Colston Budd Hunt & Kafes Pty Ltd

14 February, 2013

**RE: PROPOSED REDEVELOPMENT
OF HURSTVILLE PRIVATE HOSPITAL**

1. As requested, we are writing to set down our responses to matters raised by the Department of Planning following the exhibition period for the above development. We have previously prepared a report¹ which was submitted with the Part 3A application.
2. In a letter dated 10 January 2013, the Department of Planning has raised a number of matters relating to transport and accessibility. These matters, and our responses, are provided below.

DRAWING No:
DA-084

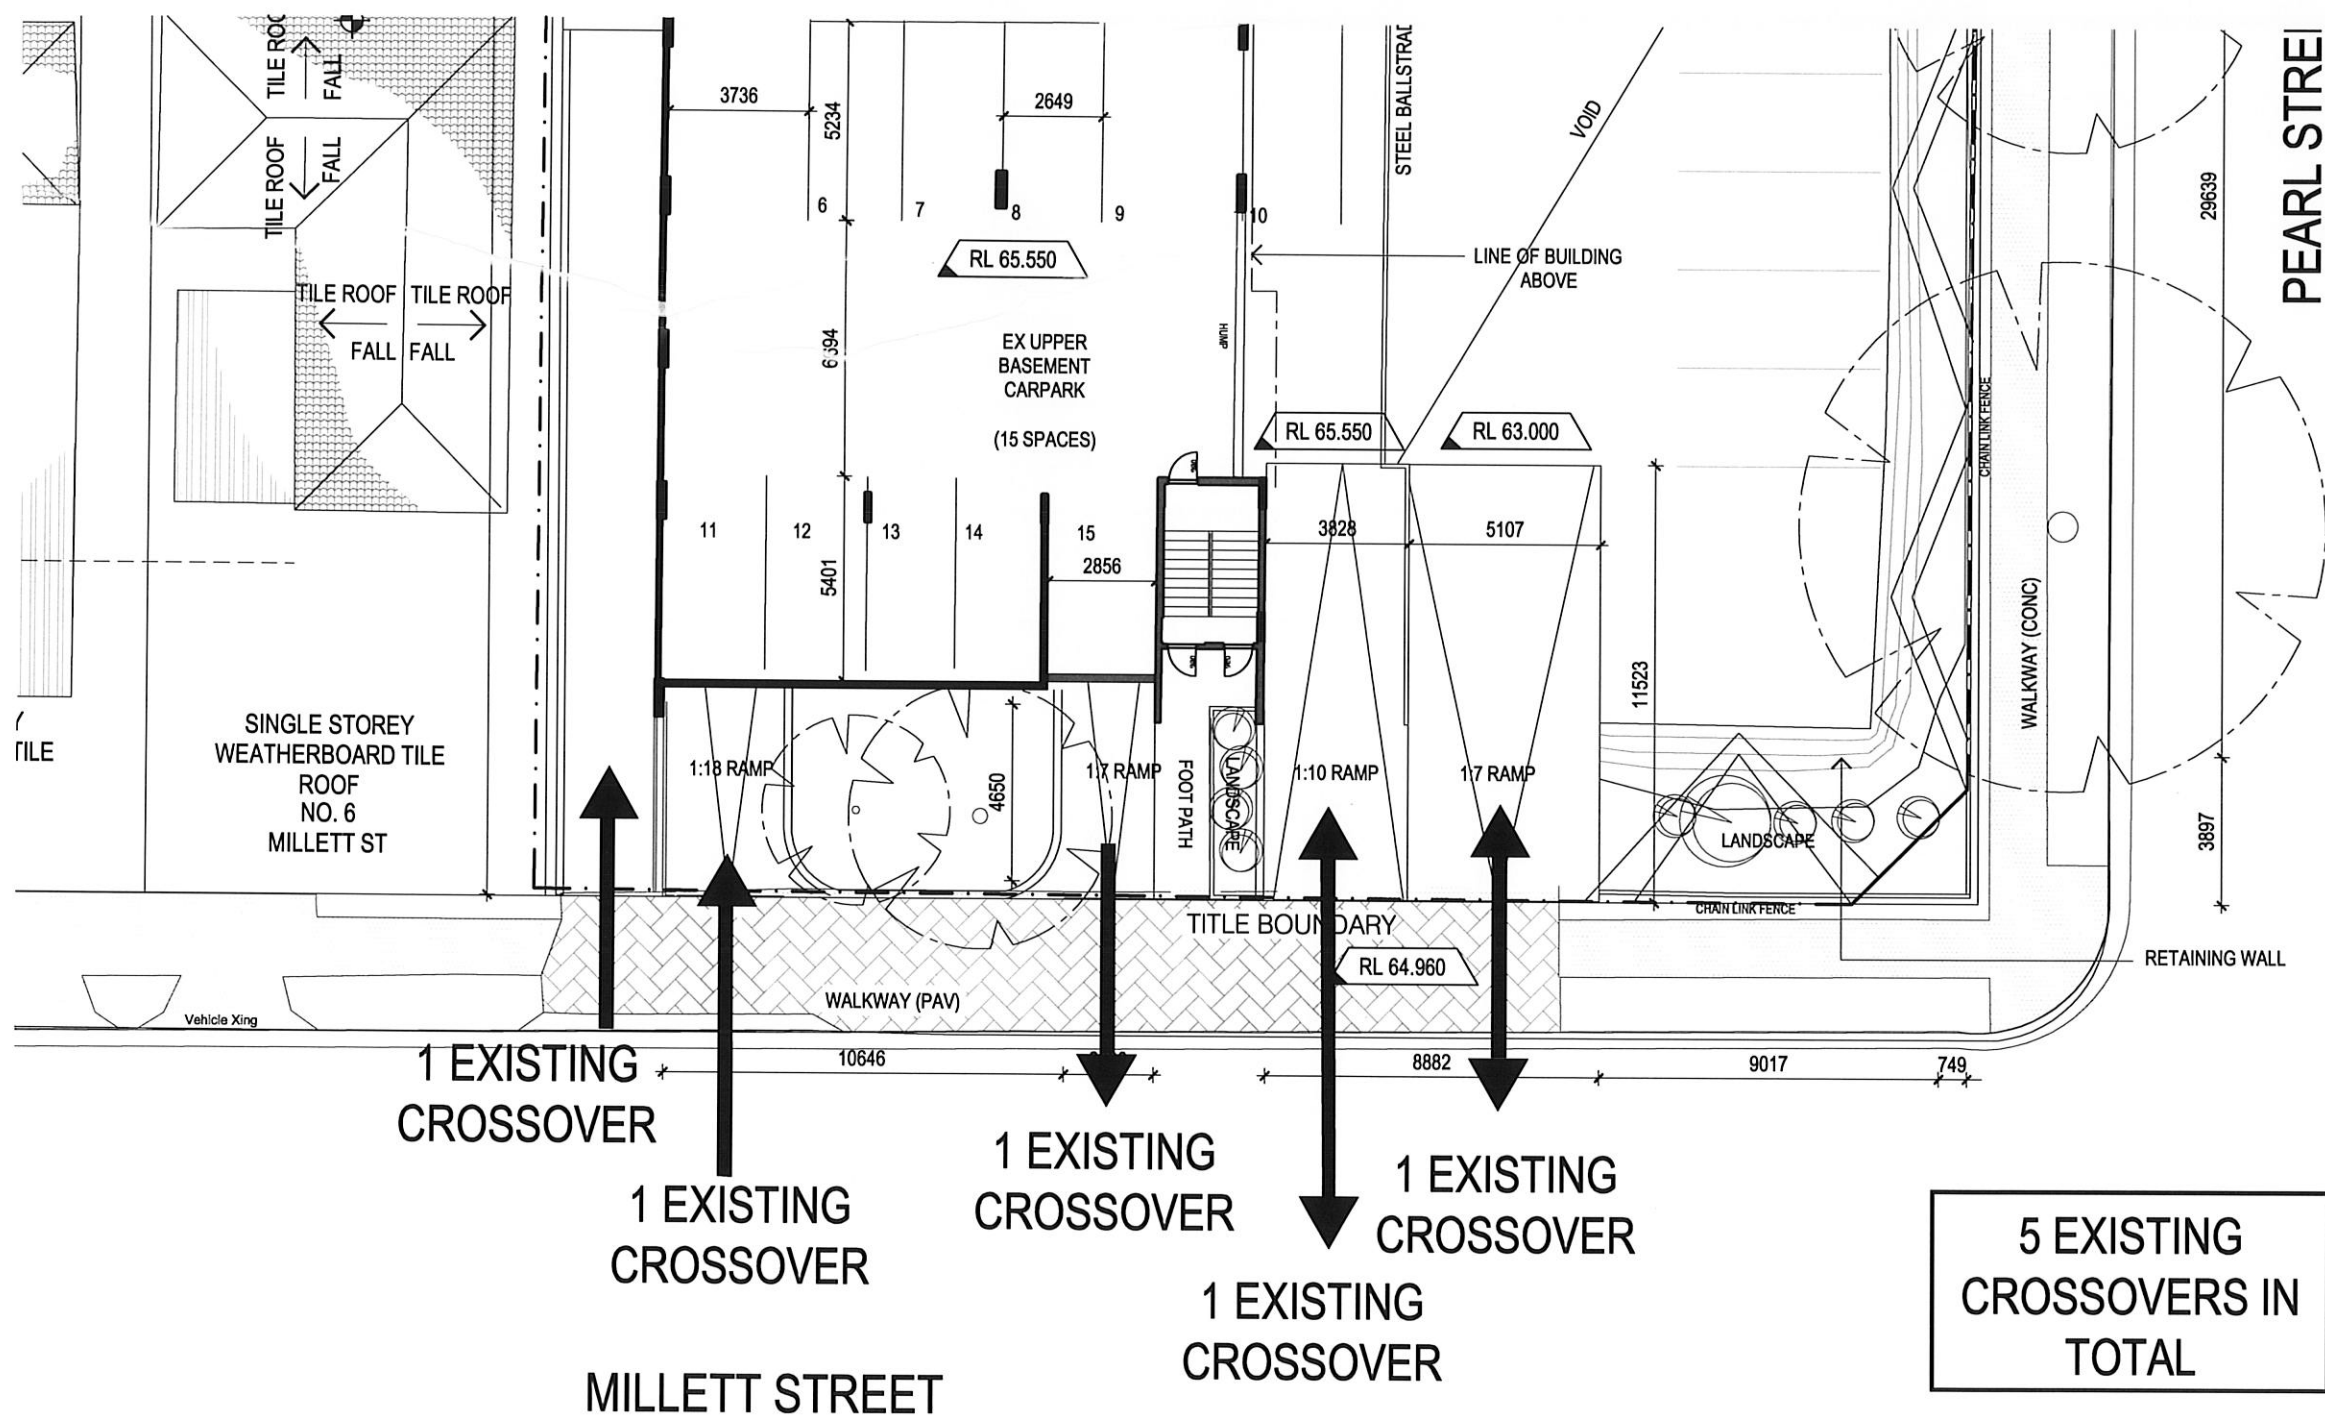
- *Amend the design to consolidate and minimise the number of vehicle entrances and exits and crossovers on Millet St. Justify any need for more than one exit and one entry on Millet St.*
3. The existing and proposed driveways on Millett Street are shown in the attached drawings prepared by the architect (DA-085 and DA-086). The number of driveways on Millett Street will reduce.
 - *Demonstrate that driveways comply with Hurstville DCPs and with the Australian Standard for Parking Facilities by specific reference to the relevant provisions of both.*

- *Provide more information about how the servicing of the proposed development is to be achieved and in particular, demonstrate how loading and unloading by vehicles is to occur in a forward direction only. If there is a need for reversing manoeuvres from Millet St, justify why the design cannot be amended to include forward only servicing and provide detailed documentation as to the frequency of any such servicing (including likely arrival and departure times and vehicle type) and that the frequency is in accordance with the Australian Standard for Parking Facilities by specific reference to relevant provisions.*
10. The first part of this matter is being addressed by the project architect. To provide for large service vehicles to enter and exit the site in a forward

7. Additionally, the driveway should provide for turns by service vehicles entering and exiting the development. Swept paths are attached in figures prepared by the architect (DA-083 and DA-084) show that the driveway will accommodate these turns.

15. It is therefore anticipated that there would be some two to four small to medium rigid trucks per day which may reverse between the site and Millett Street. The Australian Standard for Parking Facilities (Part 2: Off-street commercial vehicle facilities), AS 2890.2 – 2002, indicates that “regular service” (more than once per day) from a “minor road” (road carrying predominantly local traffic, such as Millett Street) should occur in a way that only one reverse manoeuvre occurs either to or from the street. The design provides for vehicles to enter and exit the site using one reverse manoeuvre, as shown in the attached drawings DA-083 and DA-084, prepared by the architect.
